CHENNAI METROPOLITAN DEVELOPMENT AUTHORITY
Thalamuthu Natarajan Building, No.1, Gandhi Irwin Road, Egmore.
Chennai - 600 008
Phone : 28414855 Fax: 91-044-28548416
E-mail: mscmda@tn.gov.in, Web site: www.cmdachennai.gov.in

Letter No.PP/SB/C/ 116 /2019, Dated: 22.05.2019

Sub: CMDA – Area Plans Unit - ‘B’ Channel (Central) - Planning Permission for the proposed construction of Ground floor + 4 floors Residential building with 143 dwelling units and 2 Nos. of Shops in Ground floor (92.07 sq.m) at S.No. 352/2B2 of Thirunindarvur village within the limit of Thirunindarvur Town Panchayat – Remittance of DC & Other charges – DC advice Sent – Reg.

DRAWING TITLE:
SECTION & ELEVATION

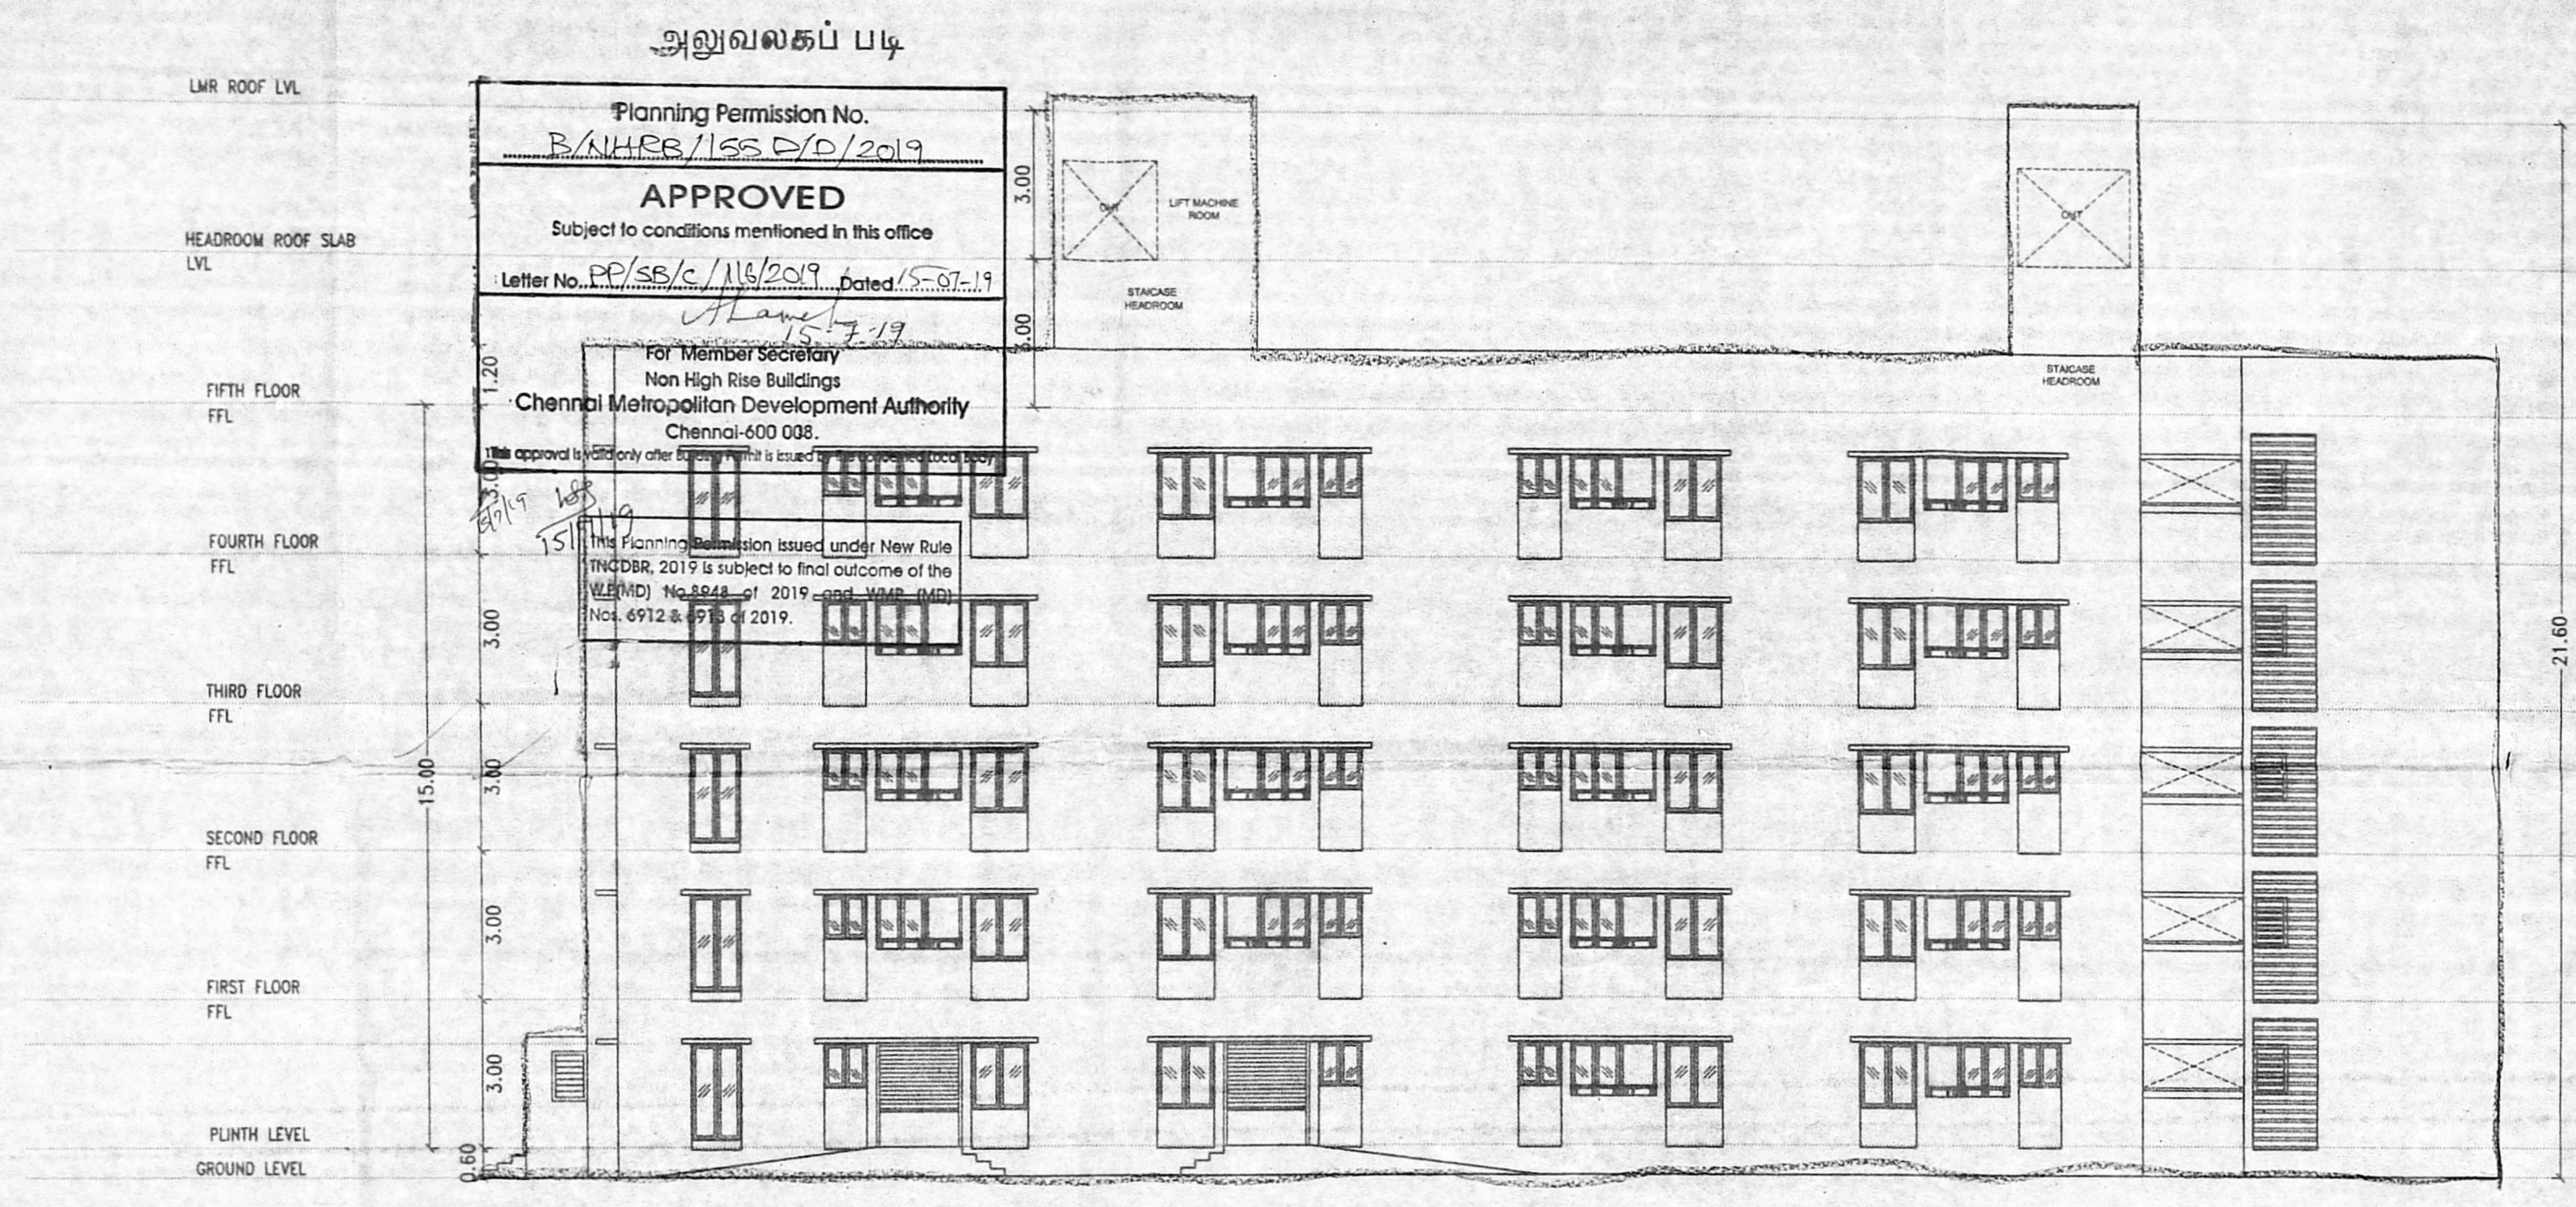
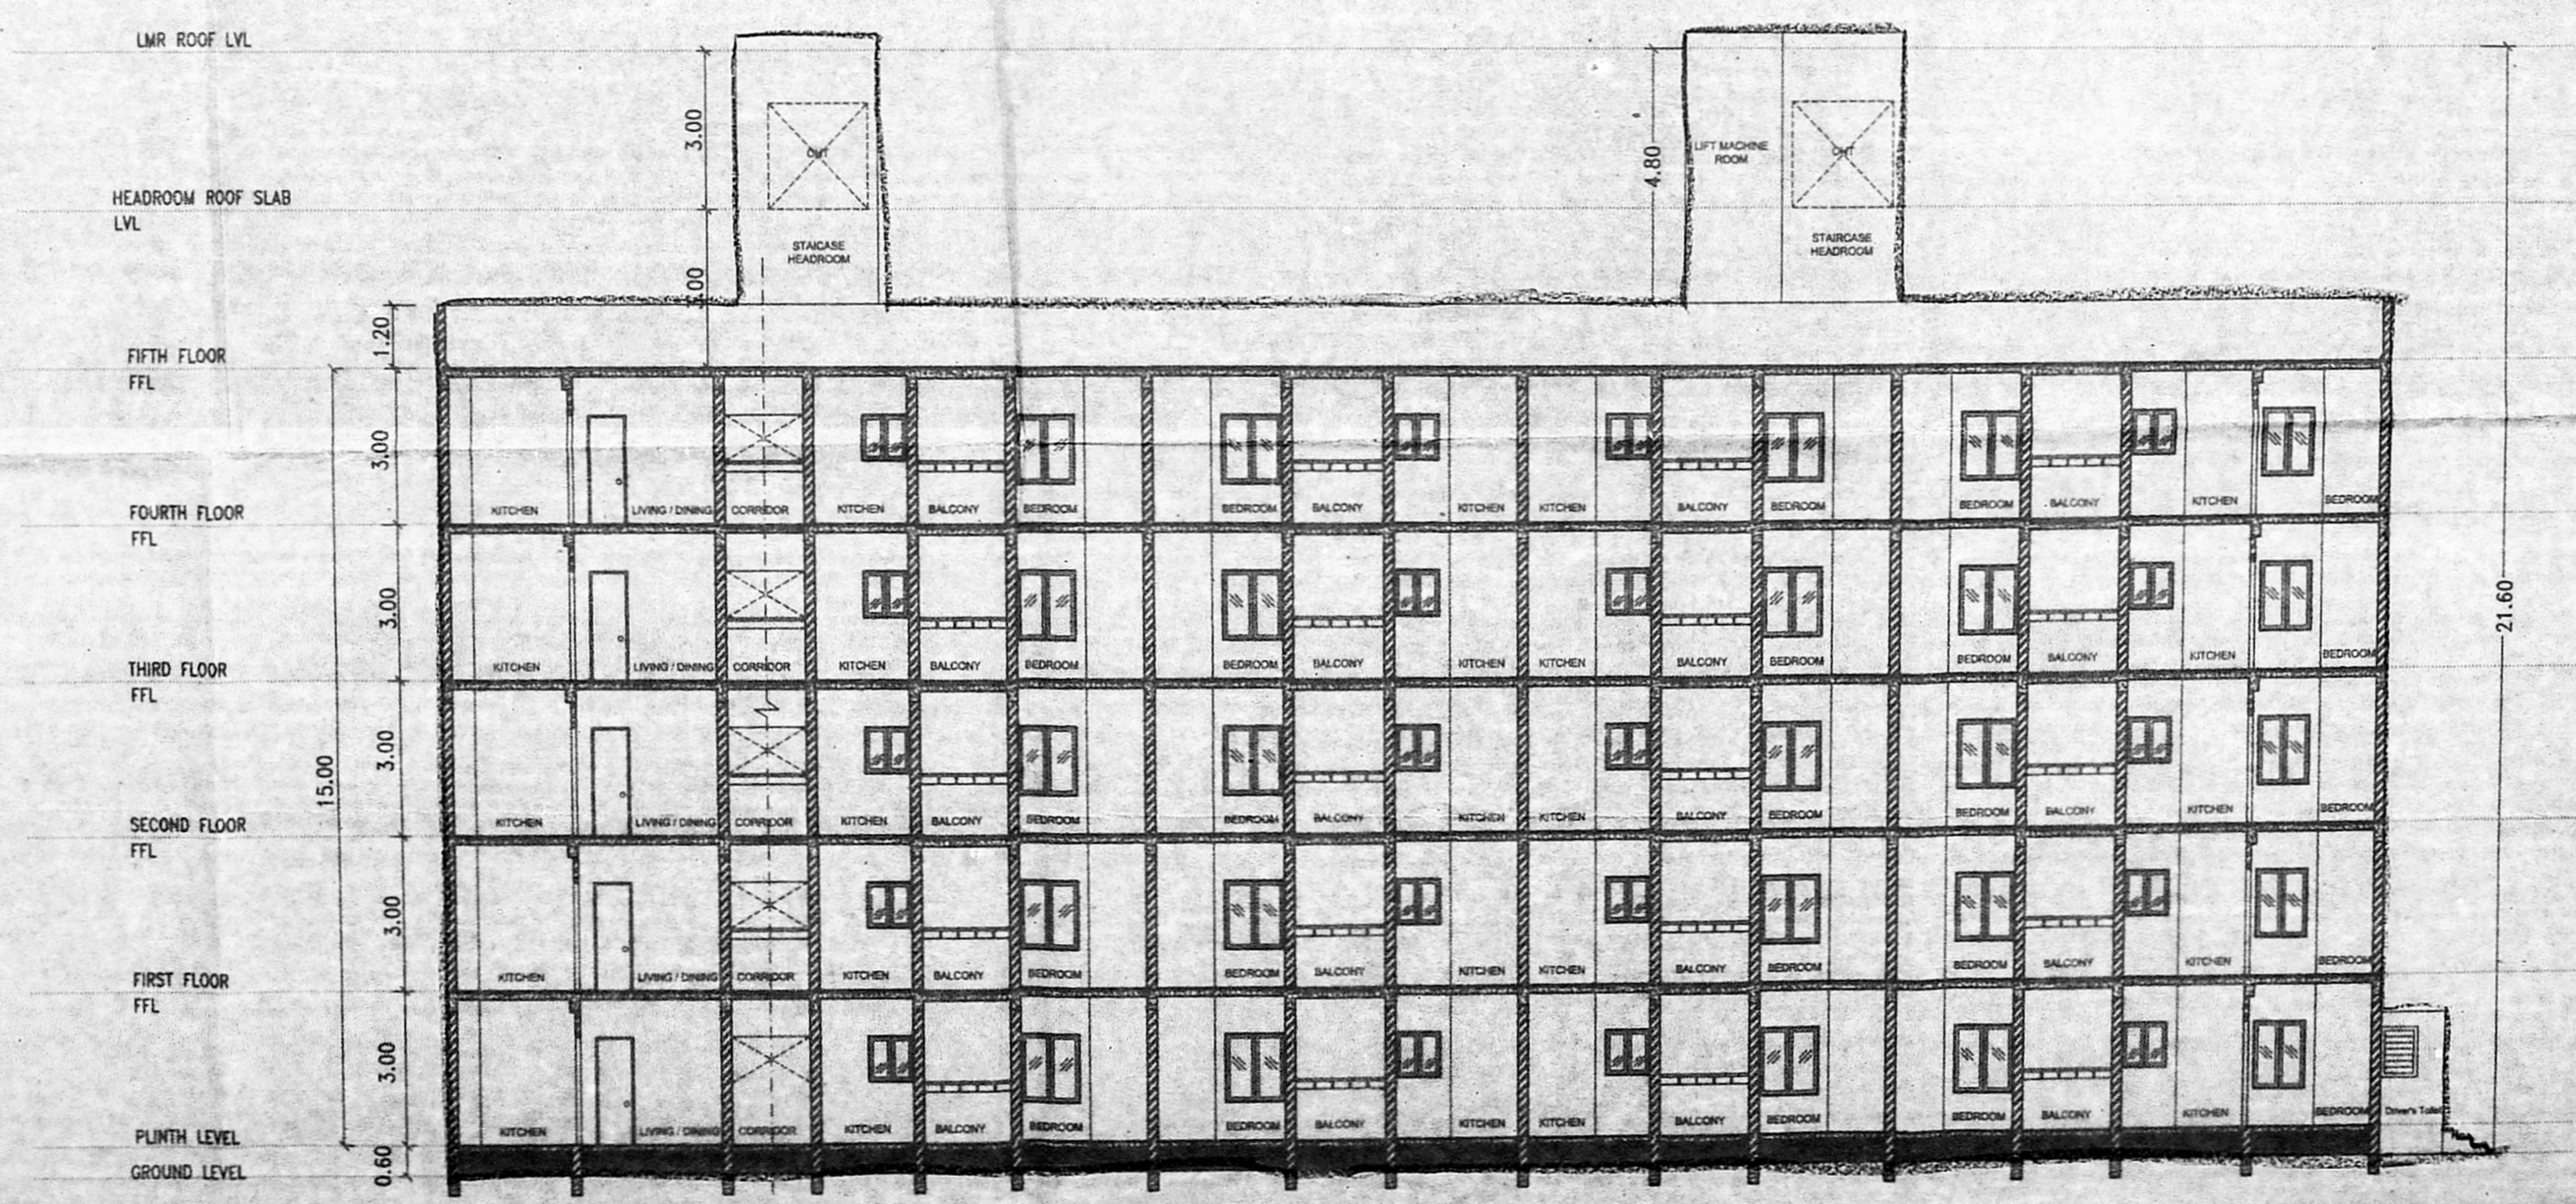
4. Judgment copy in O.S.No.13/2006 and 60/2006 in District Munisip Court, Poonamallee to be furnished..
 5. Section and Elevation to be shown correctly.

14. Steps to be provided for caretaker room.
 15. GL to be shown correctly in section & elevation plan.
